Tel: 01903 737756
Email: planning@arun.gov.uk
www.arun.gov.uk/planning
Please ask for: Ms Iqraa Malik
Email: iqraa.malik@terraquest.co.uk
Telephone: 0121 234 1390
Our Ref: M/91/25/HH
Your Ref:
Date: 10th November 2025

Application for Planning Permission for Works or Extension to a Dwelling

Development: Two storey front, rear and side extensions. Loft extension. Internal alterations.
Location: 15 Old Point Middleton-On-Sea PO22 7RY

EXISTING ROOF PLAN
 Sc. 1:100

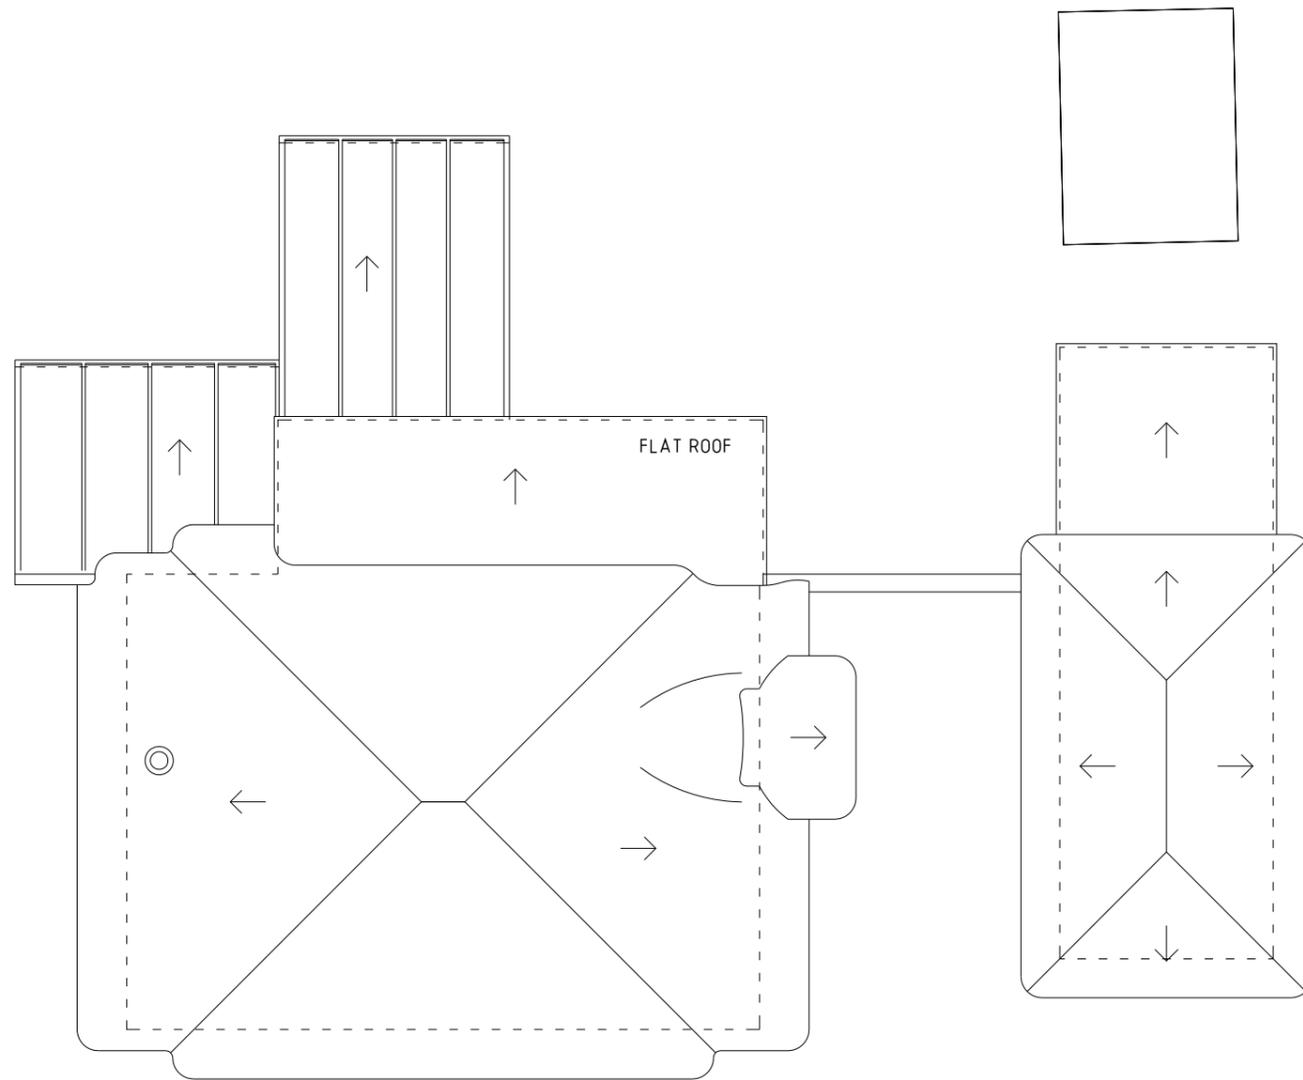
The existing roof plan has been labelled as first floor plan, please review and amend.
